Subdivision Name Huning Castle Addn B1 B2 C1 C2

DRB Application No: **04DRB-00091 (P&F)**  
Project Name: **HUNING CASTLE ADDITION**  
Agent: Billy Baca

**DEVELOPMENT REVIEW BOARD--SPEED MEMO**

**RE: Lots B & C, Block 29, Huning Castle Addition/minor plat**

THE PURPOSE OF THIS PLAT IS TO DIVIDE LOTS B AND C INTO FOUR (4) LOTS AND GRANT ANY EASEMENTS AS SHOWN.

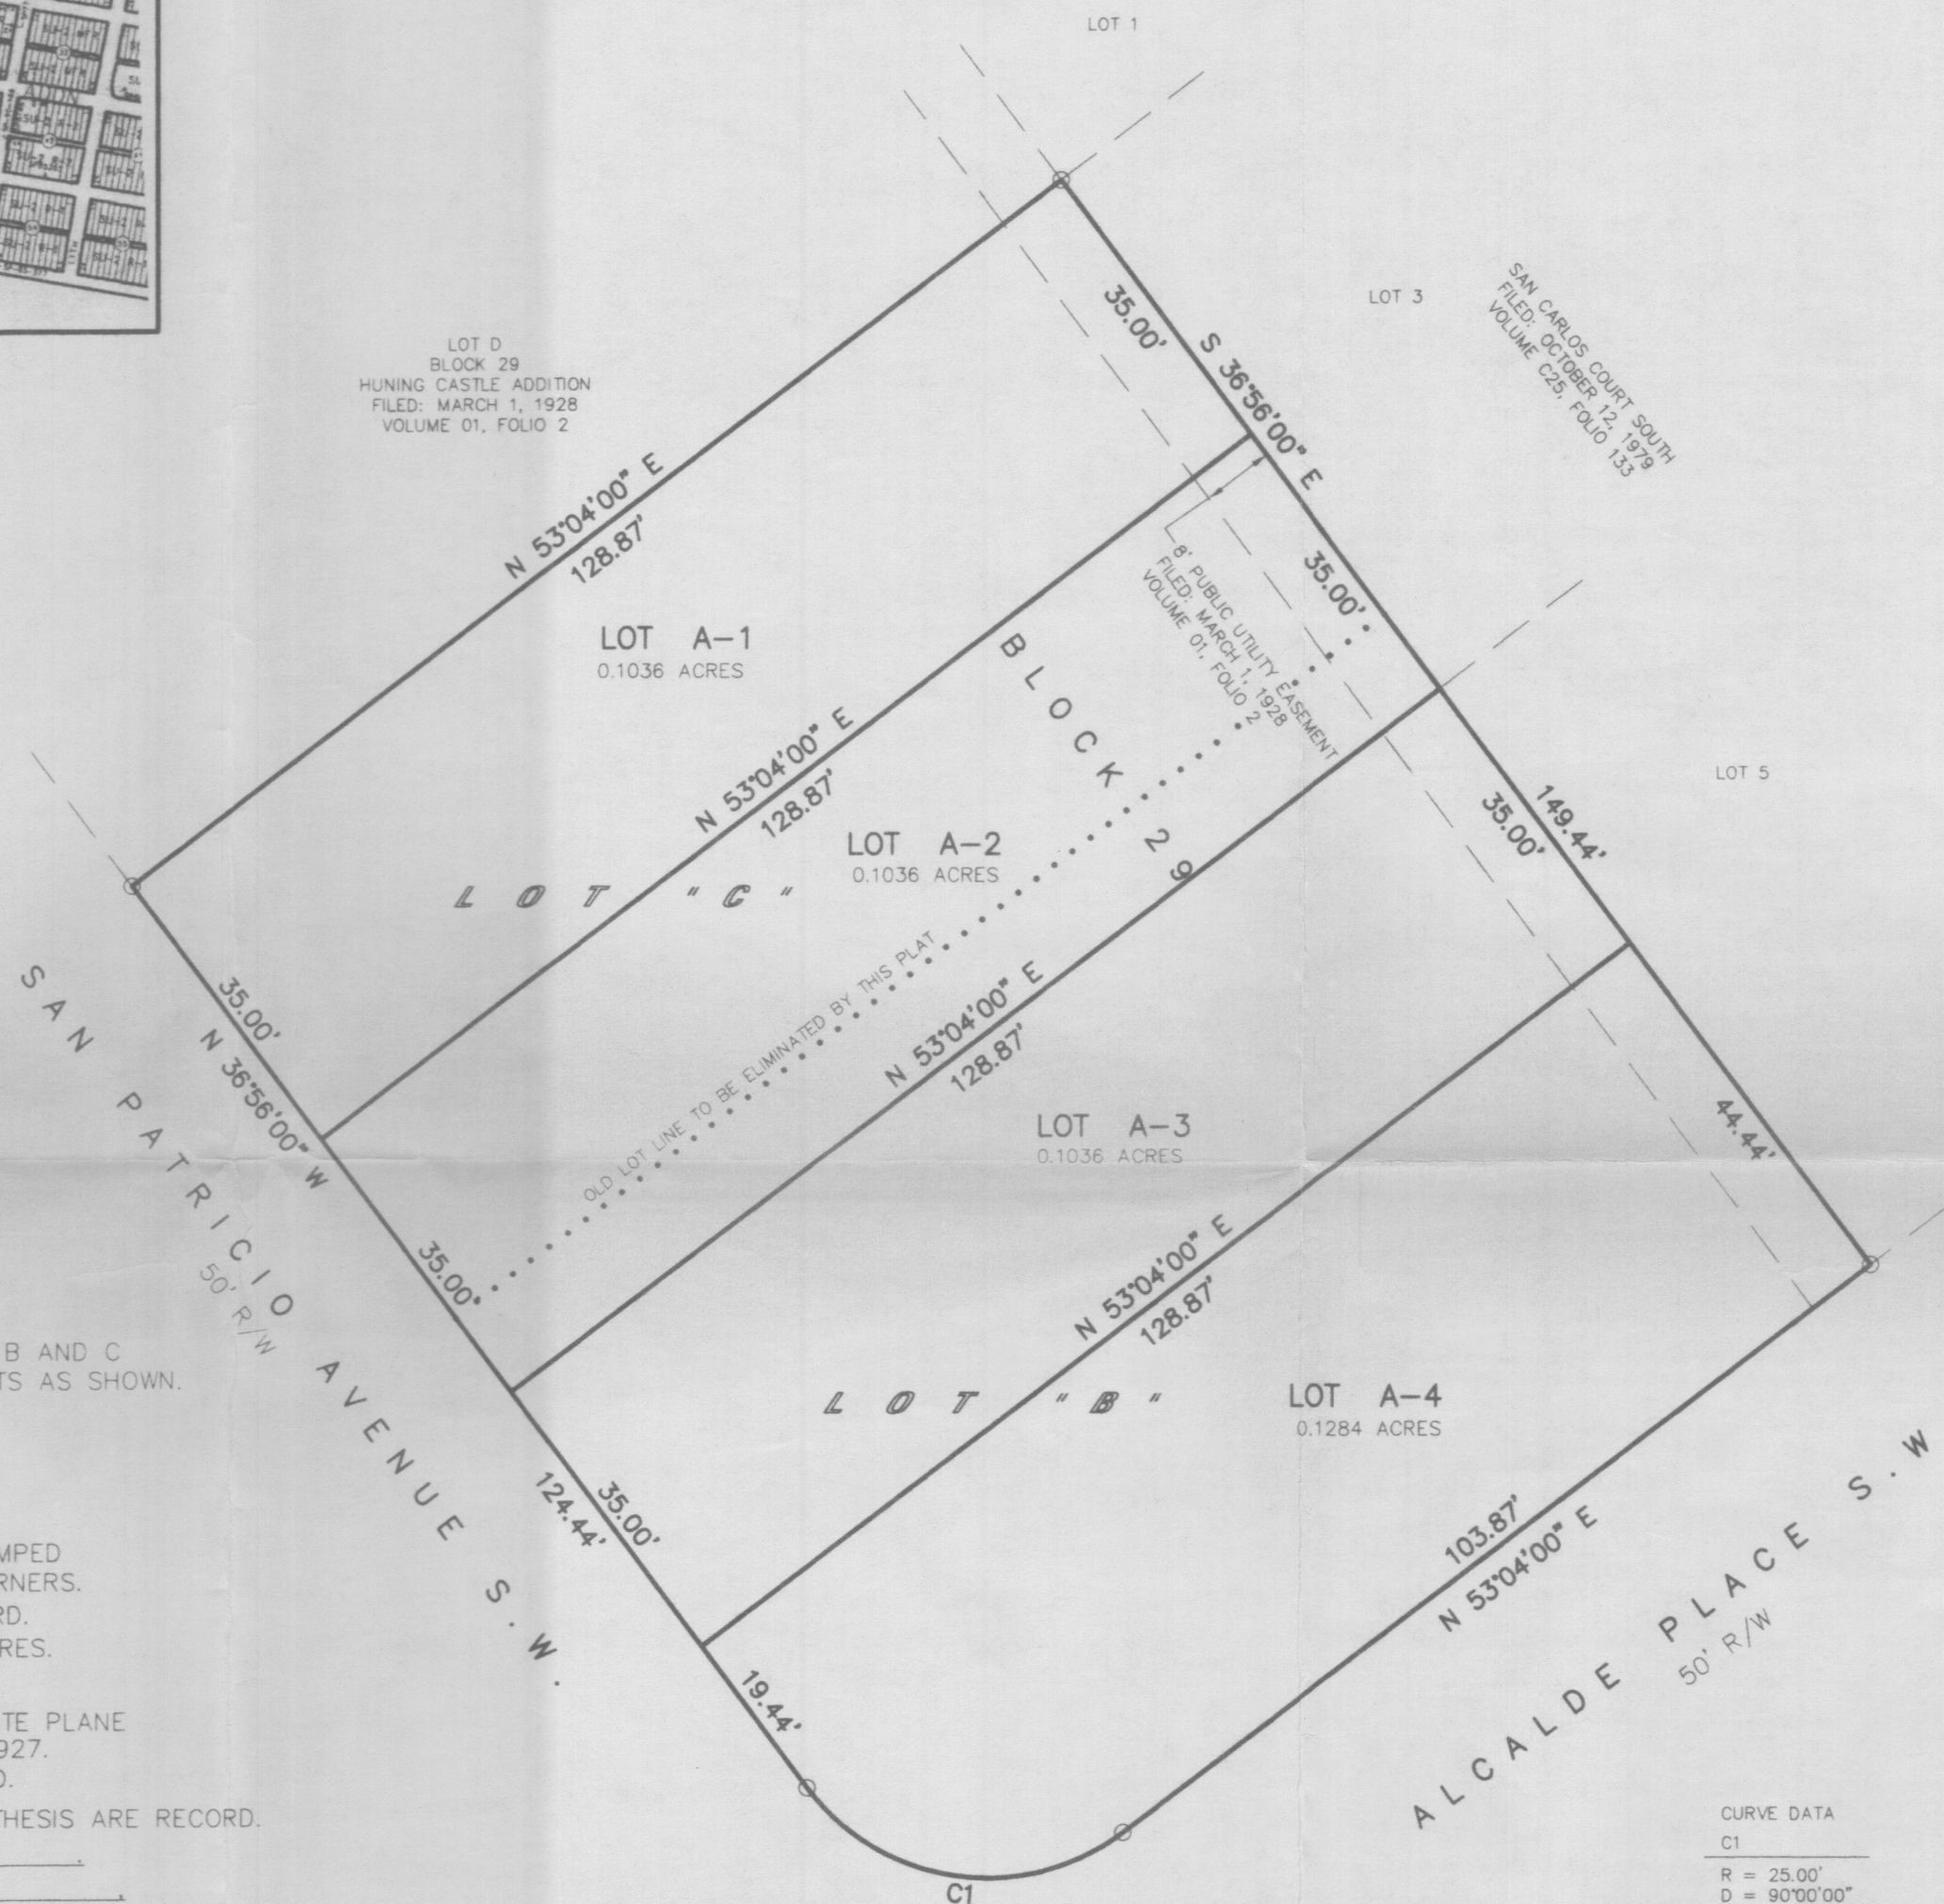
No.	Comment
	(1) NEED SKETCH OF STREET X-SECTIONS w/ RELATION TO PROPERTY BOUNDARY
	(2) WHERE WILL LOT A-4 TAKE ACCESS FROM?
	(3) 35' LOT WIDTH IS NARROW - DRIVE CUT CRITERIA MUST BE MET (DPM) SHOW EXISTING & PROPOSED DRIVE PADS - SKETCH
